Subject: Flying Horse North Lot 35, PCD File No. SF-18-042

Please accept this letter as our response to comments to your letter dated December 27, 2018. Our response to items are in RED below.

FLYING HORSE NORTH FILING NO. 1A  
1096.09  
NOVEMBER 12, 2018  
SHEET 1 OF 2

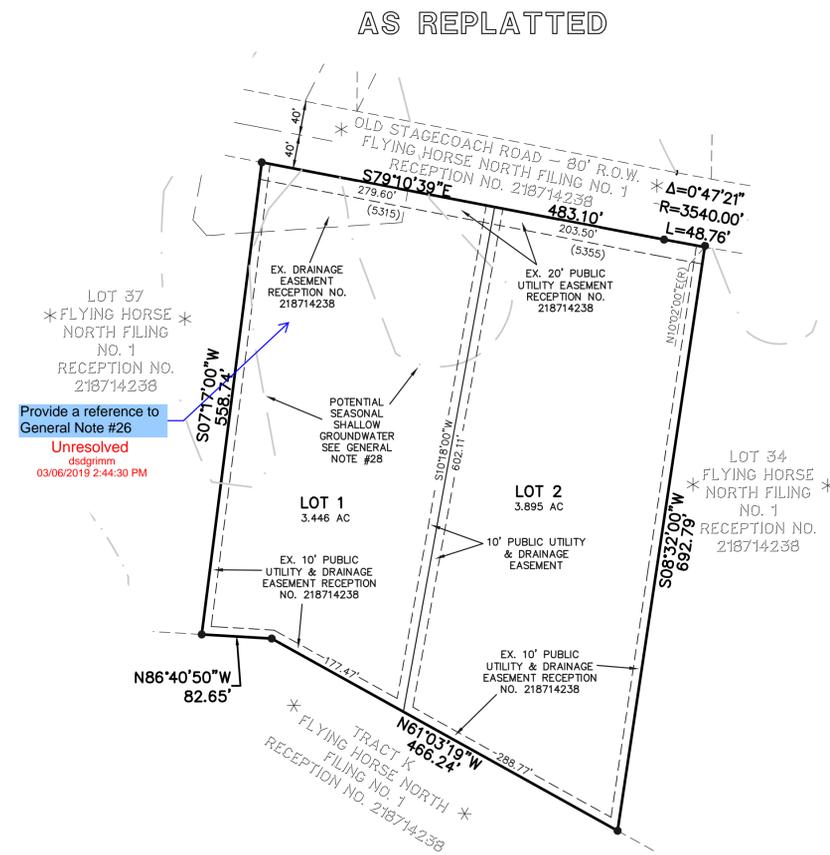
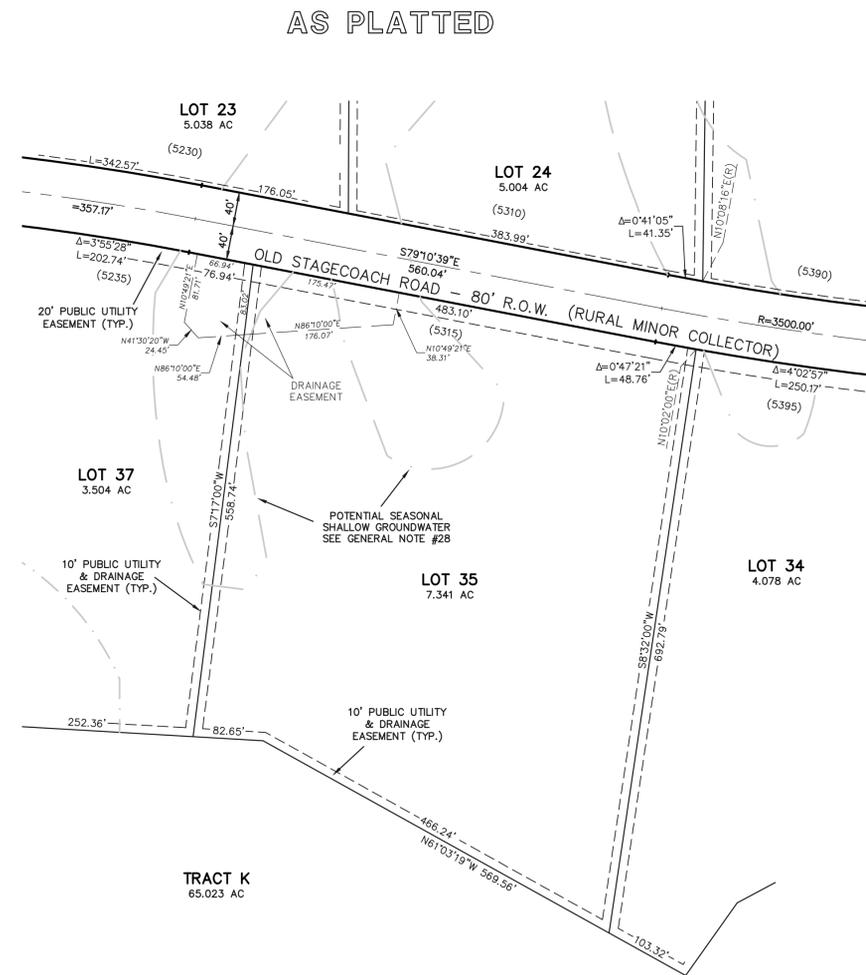
Engineering comments have been provided on the Plat Drawing

1- The easement shown at the northwesterly corner of the plat created in Flying Horse North Fil, No. 1 is for storm water crossing the Old Stagecoach Road it is not for a driveway so note 26 does not pertain to this easement.

2- The PCD file no. s been added.

3- Note 26 has been revised to include "both".
